**From:** Carmichael Ian <Ian.Carmichael@thamesvalley.pnn.police.uk>  
**Sent:** Thursday, September 12, 2019 10:35 AM  
**To:** Shona King <Shona.King@Cherwell-DC.gov.uk>  
**Cc:** Planning <Planning@Cherwell-DC.gov.uk>  
**Subject:** Planning ref: 19/01410/RES. 10 dwellings on Land adjacent to Cotswold Country Club and South of properties on Bunkers Hill.

**Planning ref: 19/01410/RES. 10 dwellings on Land adjacent to Cotswold Country Club and South of properties on Bunkers Hill.**

**Planning ref: 18/01491/OUT. 10 dwellings on Land adjacent to Cotswold Country Club and South of properties on Bunkers Hill.**

Project
Bunkers Hill,
Oxon
Title
Proposed Site Plan
Scale
1:500 @ A2
Date
March '19
Drawn
CP
Checked
SRH

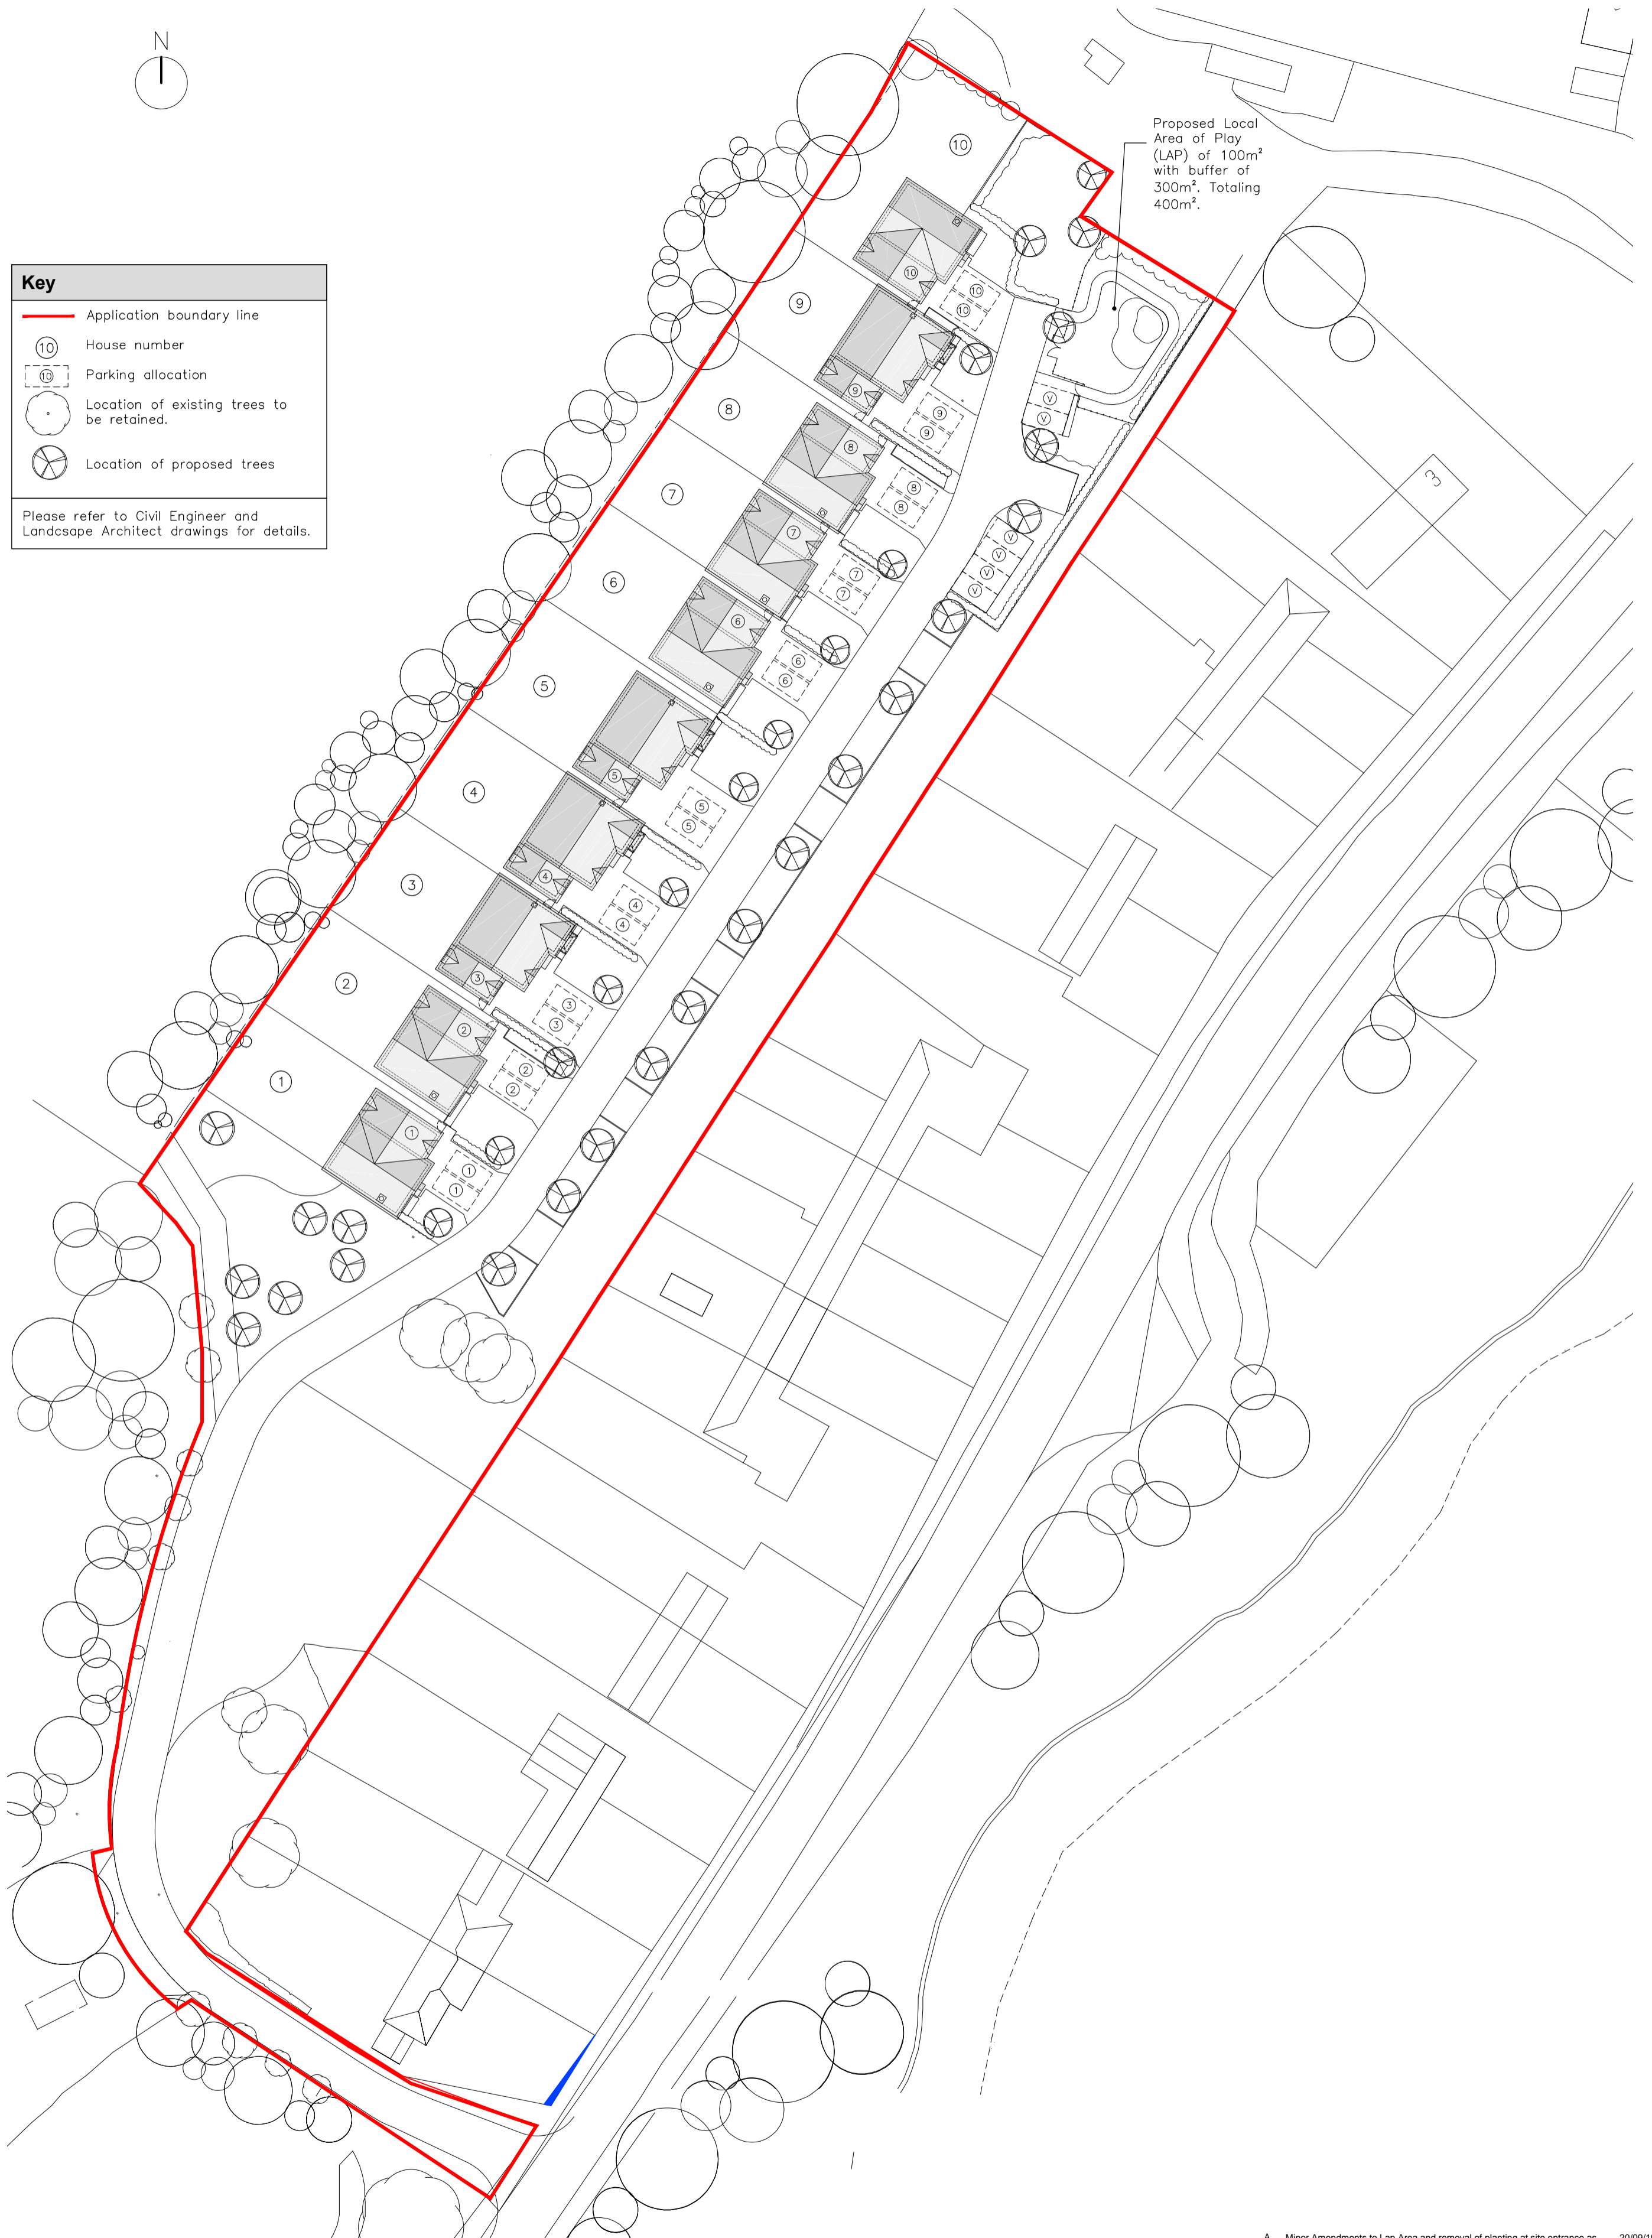
- I suggest that the existing pedestrian route at the north of the site is closed to prevent the development becoming a leaky cul-de-sac.
- I strongly recommend that the access route is lit to the standards contained within Secured by Design's (SBD) guidance for new dwellings (<http://www.securedbydesign.com/industry-advice-and-guides/>). In relation to this, and assuming lighting is provided, I would have concerns that the proposed new screen planting may impinge lighting in future; tree positions, habit and final growth height/spread must be considered.

- The landscaping scheme and maintenance plan must ensure that areas of ambiguous ownership are not created and ongoing maintenance is assured. I have concerns about the areas between driveways of the existing properties and also at either end of the site.

- The 'passing bays' must be marked as such to ensure no parking takes place at these locations, which may lead to conflicts between residents.
- Careful consideration will be needed on the type of boundary treatments used to secure the rear gardens of the proposed dwellings. Additional planting is not sufficient and materials used must be robust and suitable in the environment.

- Finally, I would prefer to see the garages of the proposed dwellings moved forward to create a continuous front building line and avoid the creation of blind corners/recesses.

Title  
Proposed Local Area of Play  
Scale 1:200 @ A3

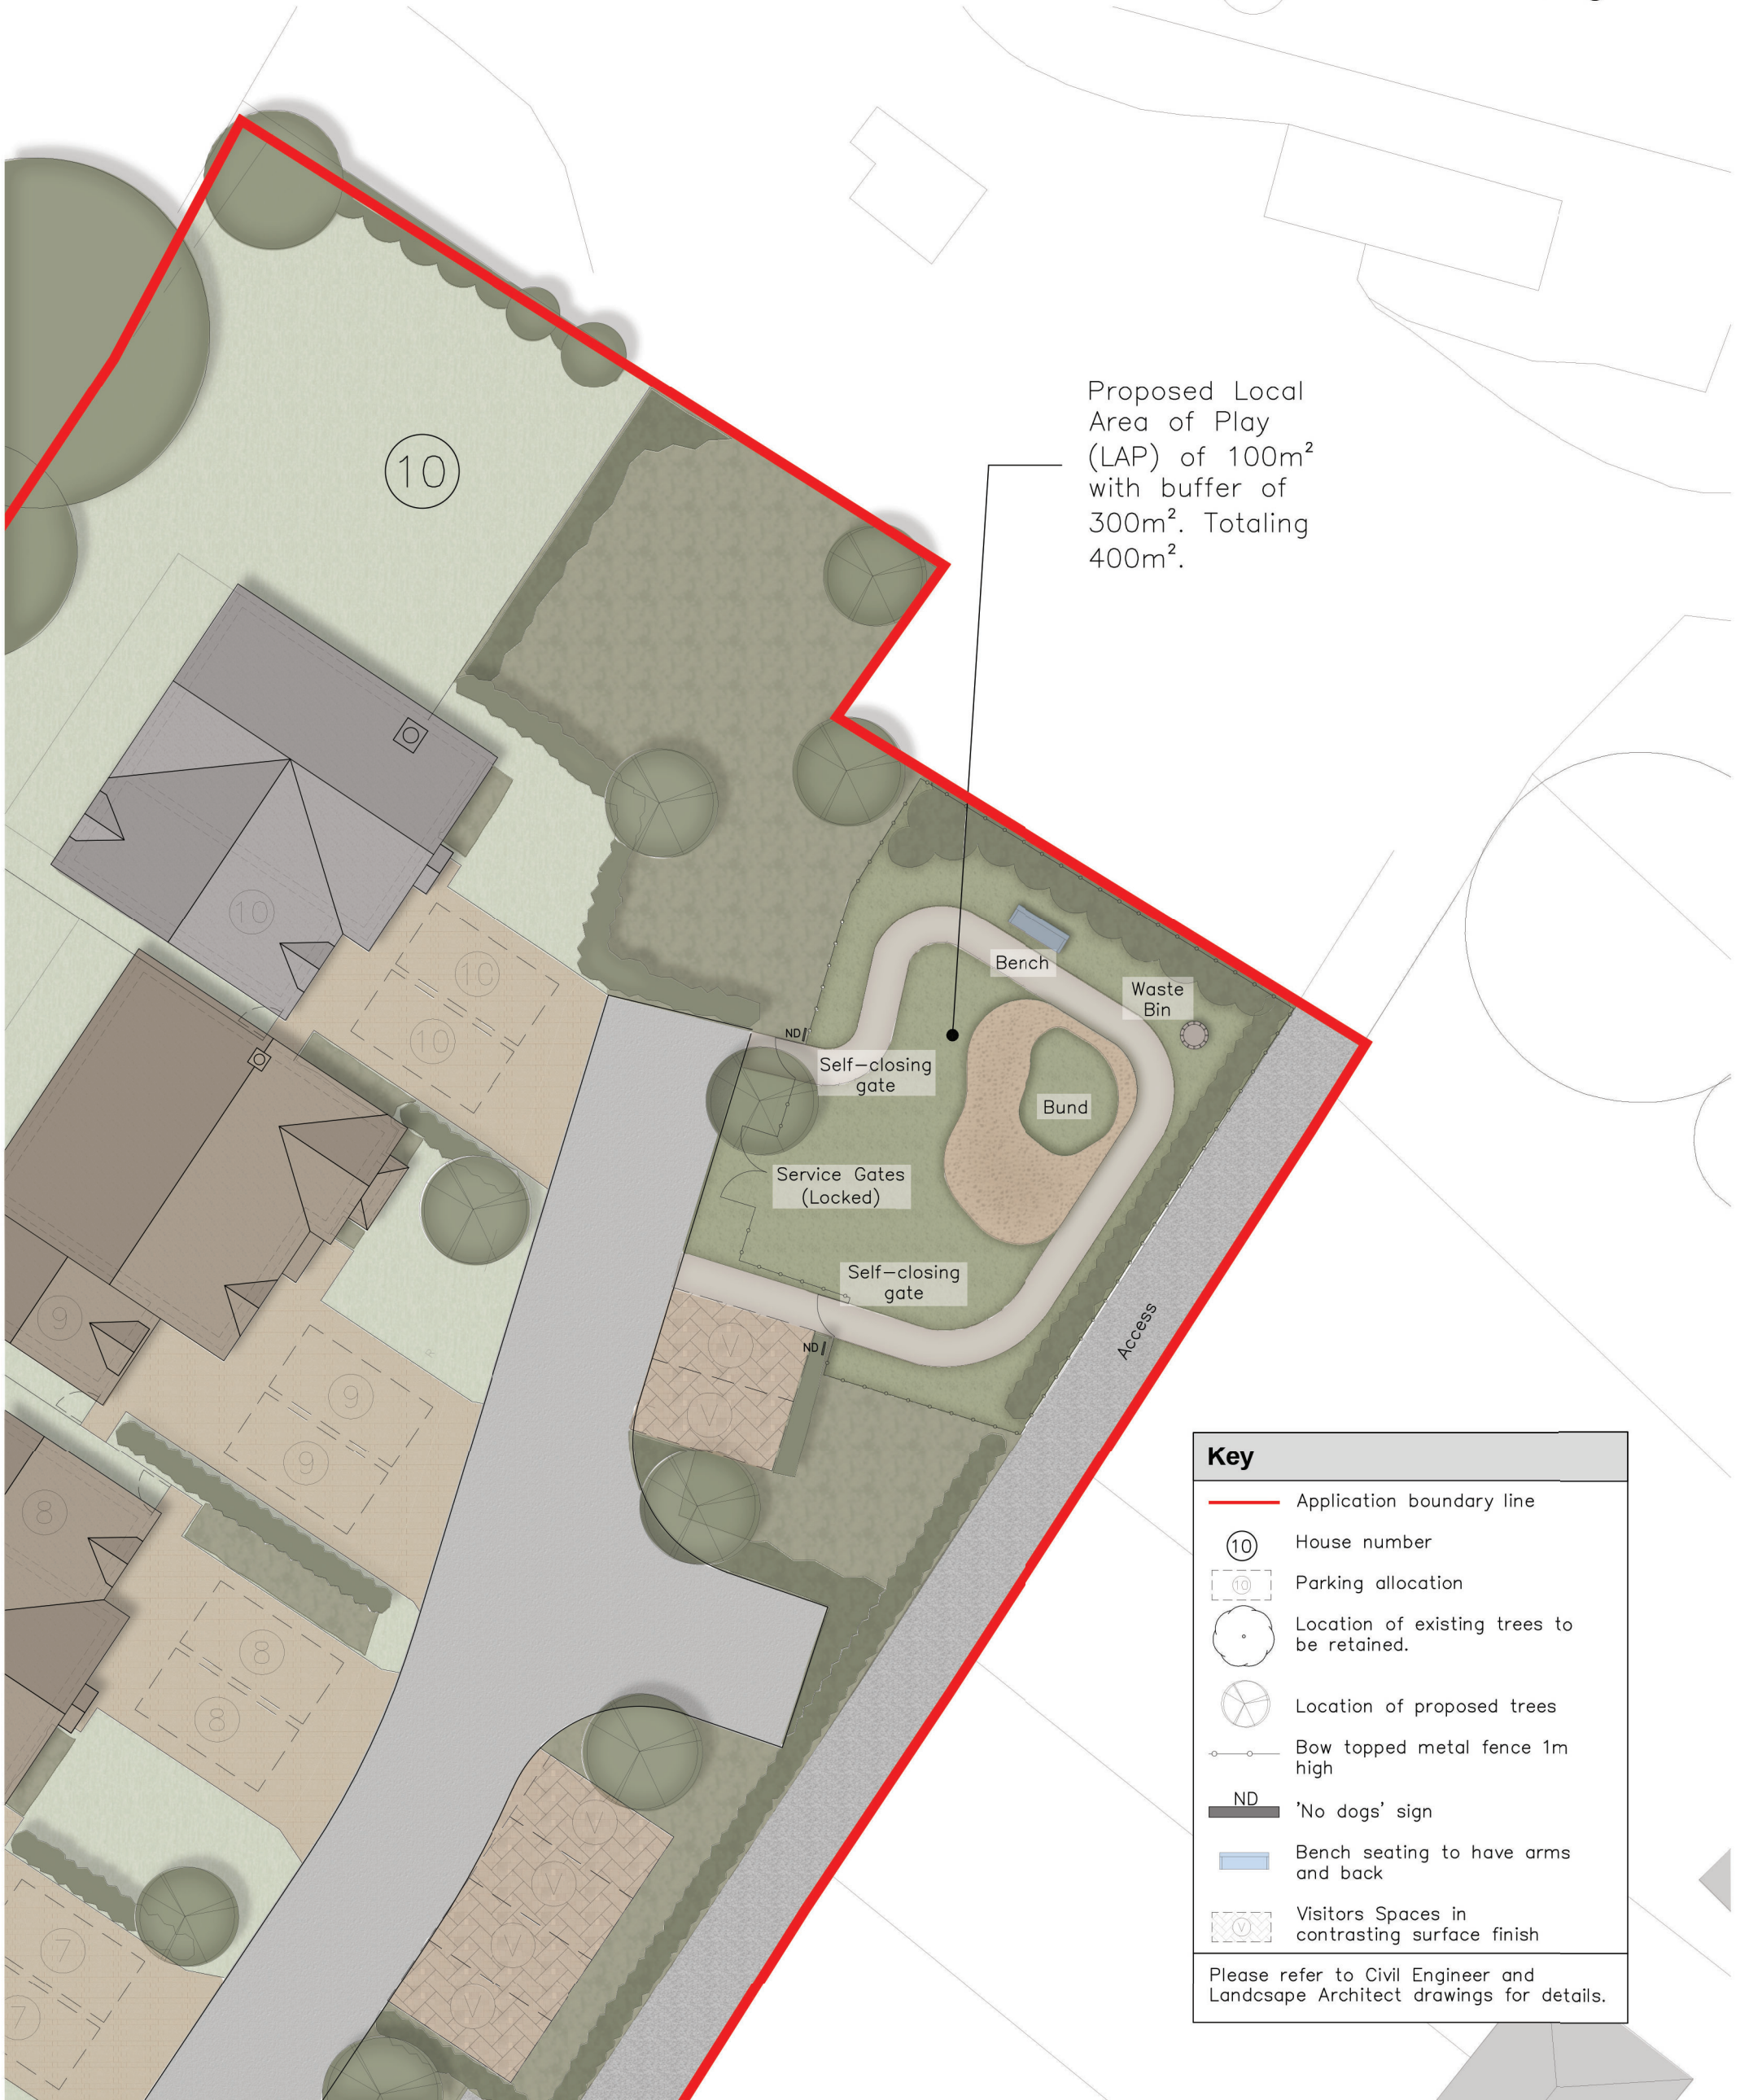
- The design of the LAP also requires careful consideration in relation to defining user group age, boundary treatment, lighting and landscaping etc. The designs should promote the ownership and enjoyment of all users as well as child safety, but they should also deter anti-social behaviour.
